RE: 2825 W. Mercer Way Preliminary Plat – Second Review SUB19-002/SEP19-005
Blueline Job No. 13-118

This letter is in response to the City's review of the 2825 W Mercer Way project. The plans have been revised per the comments in the letter, dated January 5, 2022. Below is a list of each comment with our responses in bold.

10/12/22
 JOB NUMBER:
13-118
 SHEET NAME:
GP-01
 SHT **4** OF **9**

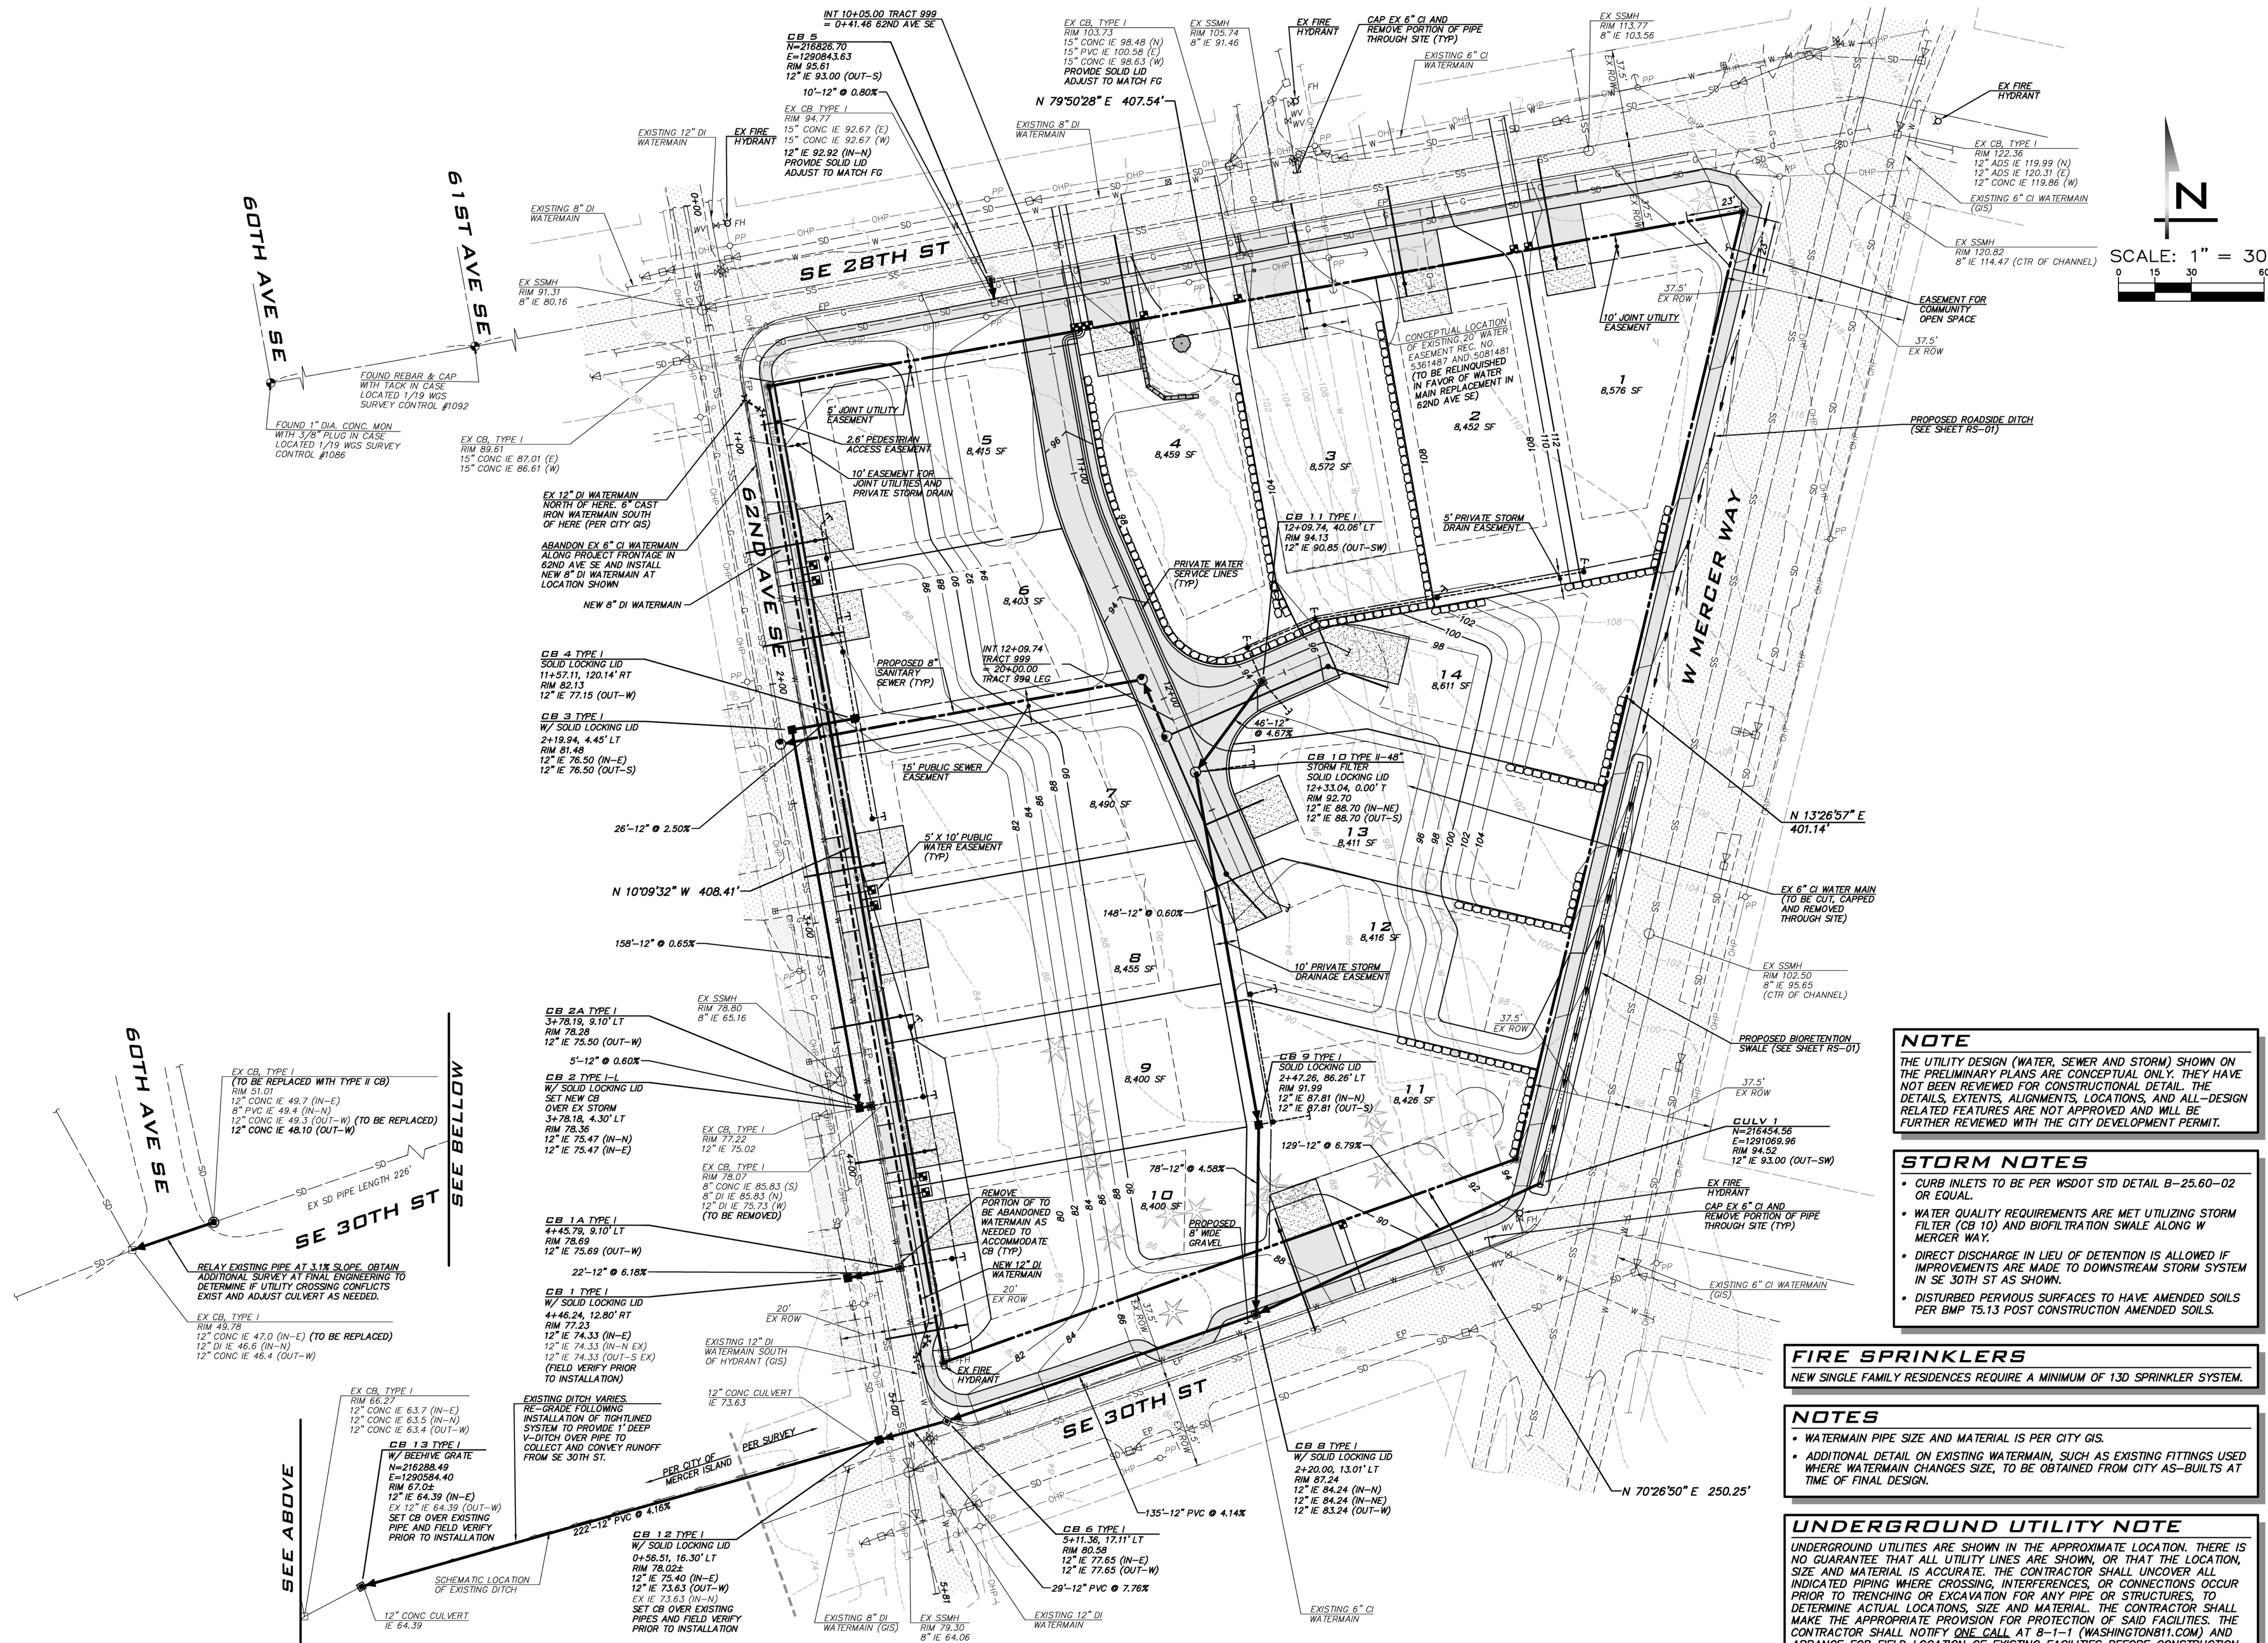
1. A new wall not shown in Sub 1 looks to be within the tree protection zone. The construction of the wall is shown encroaching into the tree protection zone. Place this wall with enough room to construct without encroaching into the tree protection zone. As suggested in a Planning comment a longer driveway would resolve this issue.

This wall was added to accommodate the lot 4 driveway while minimizing impacts to tree #2. The wall is located outside of the tree protection zone. The wall was shifted south 5' to the edge of the allowable building pad to provide additional protection. The wall can be constructed by hand along the driveway to ensure impacts are outside of the dripline.

PRELIMINARY UTILITY PLAN
2825 W MERCER WAY
PRELIMINARY PLAN
 PARCEL #2174502425
 CITY OF MERCER ISLAND WASHINGTON

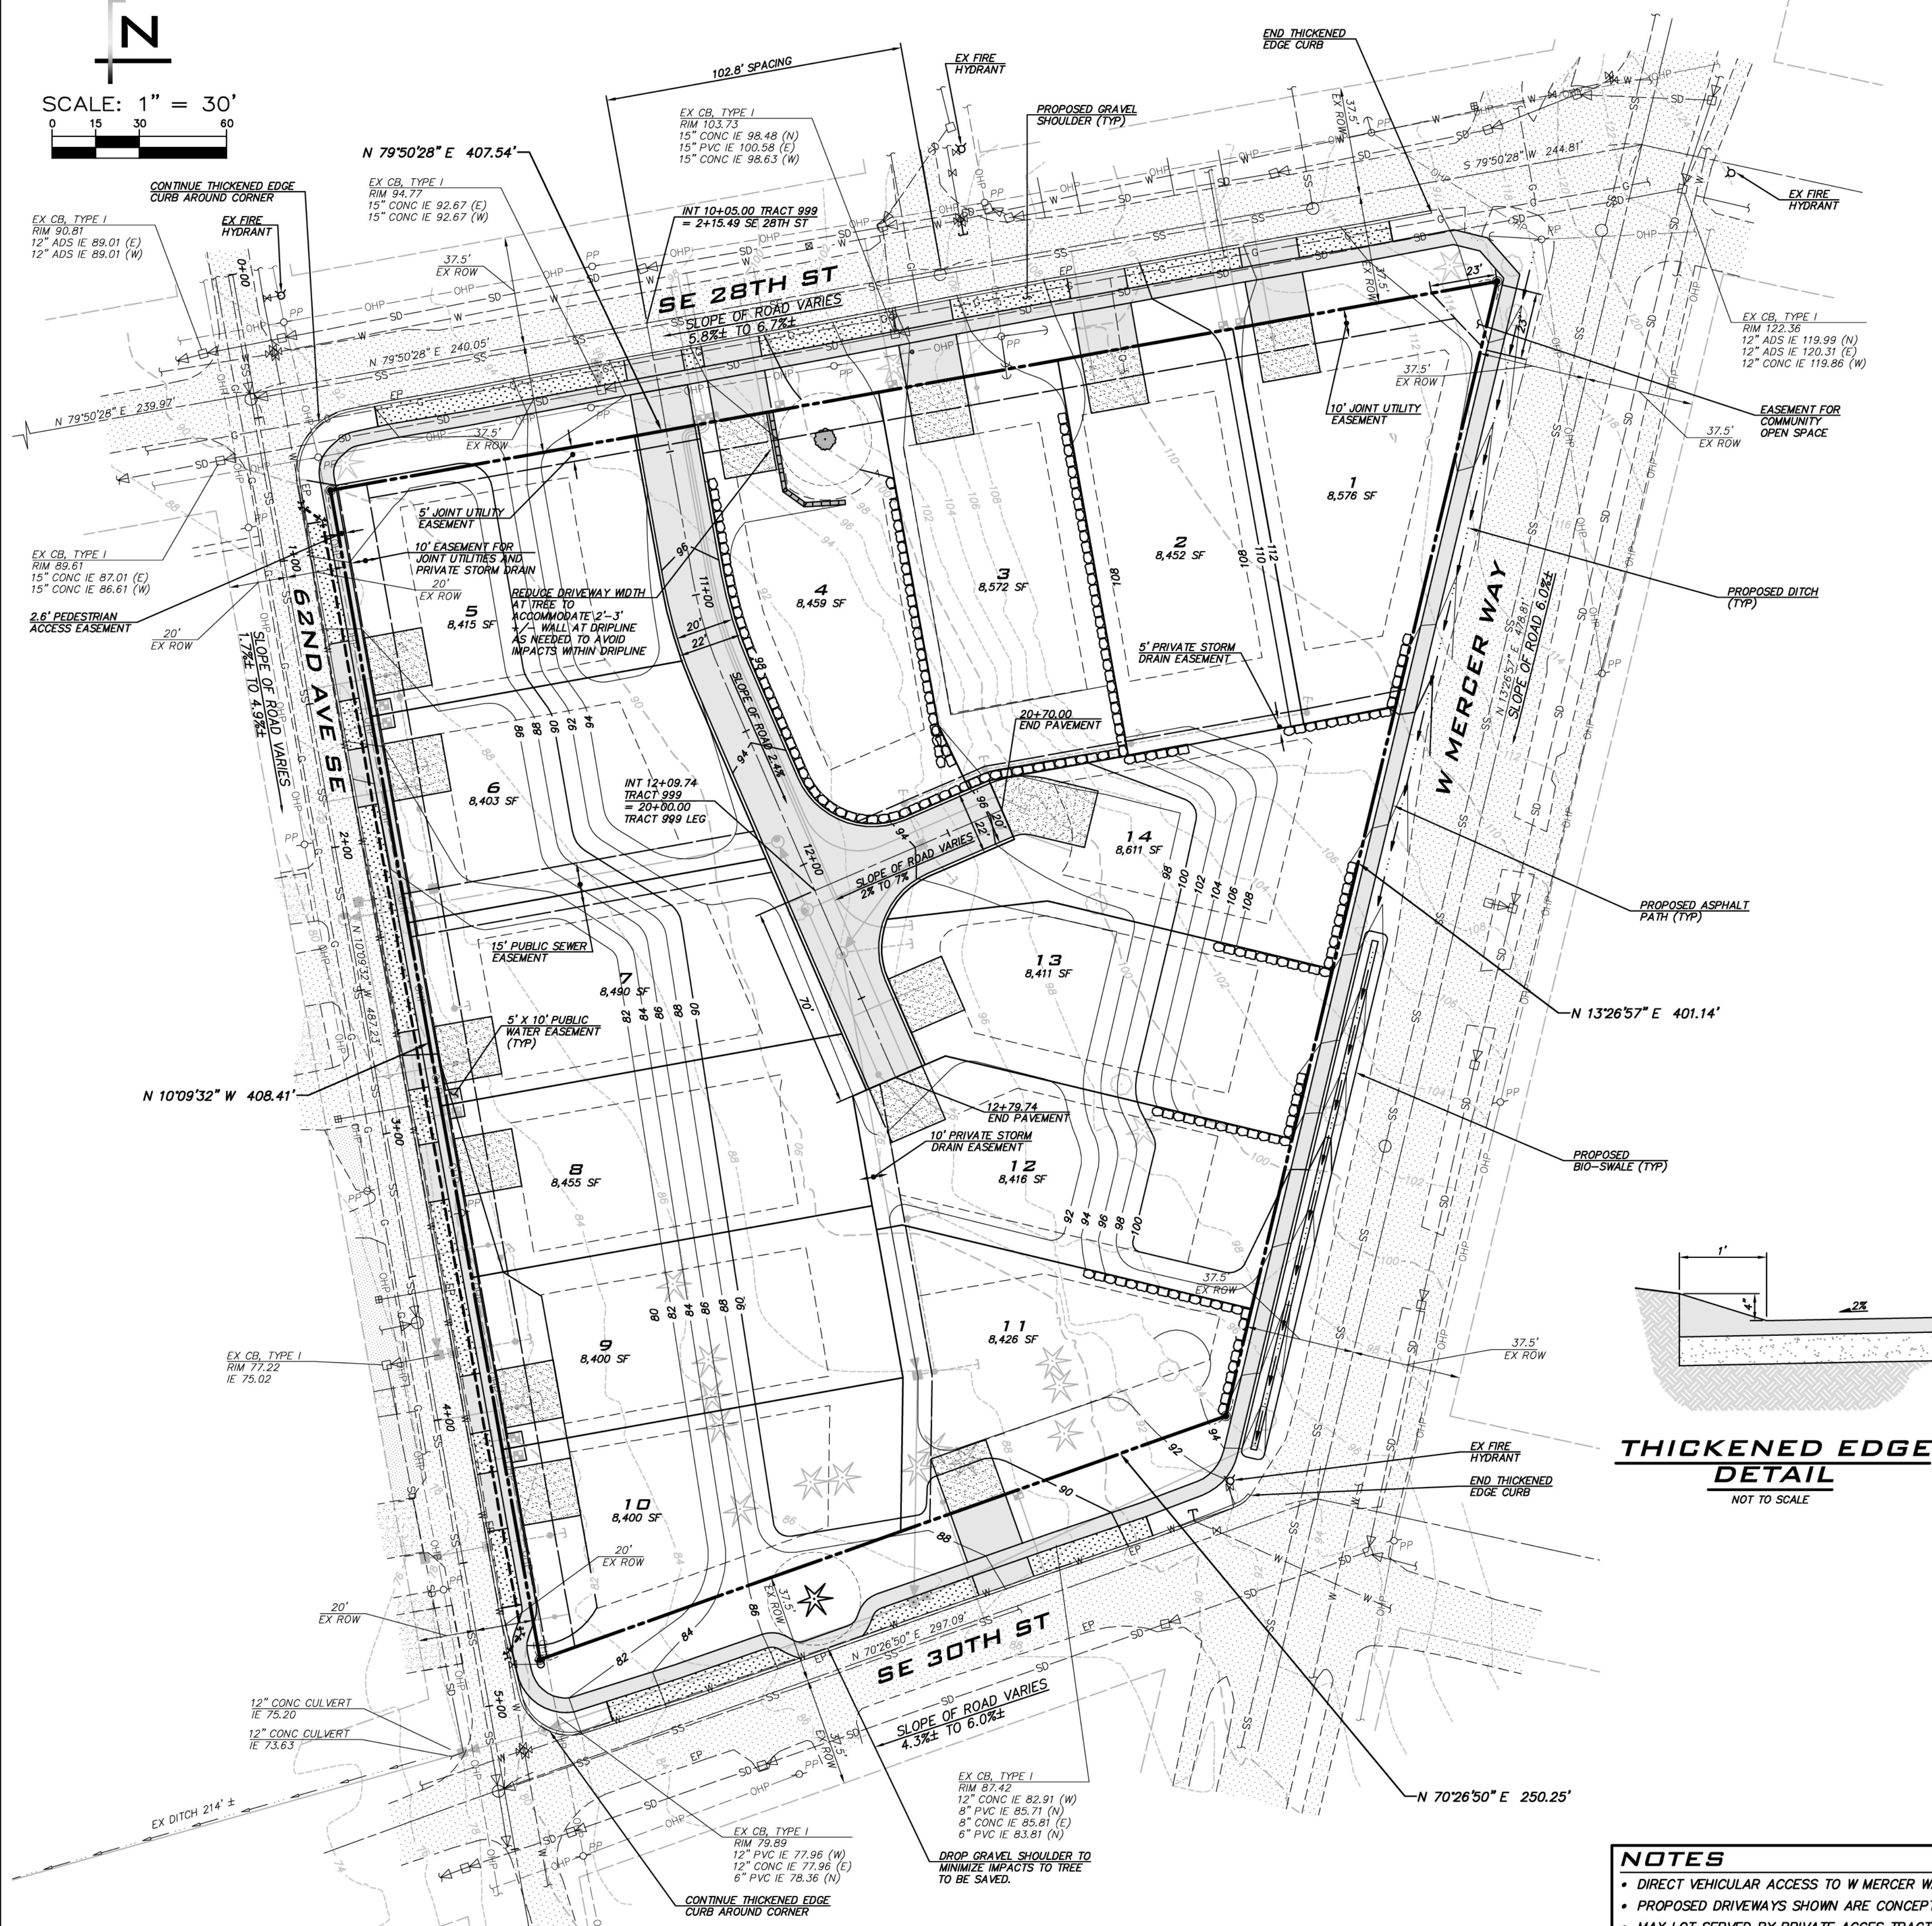
- 5. The downstream drainage system along SE 30th Street shall be improved as a part of this project. Please provide a conceptual drainage design.

The downstream drainage system along SE 30th St was updated to address recommendations from the City's stormwater operations team.
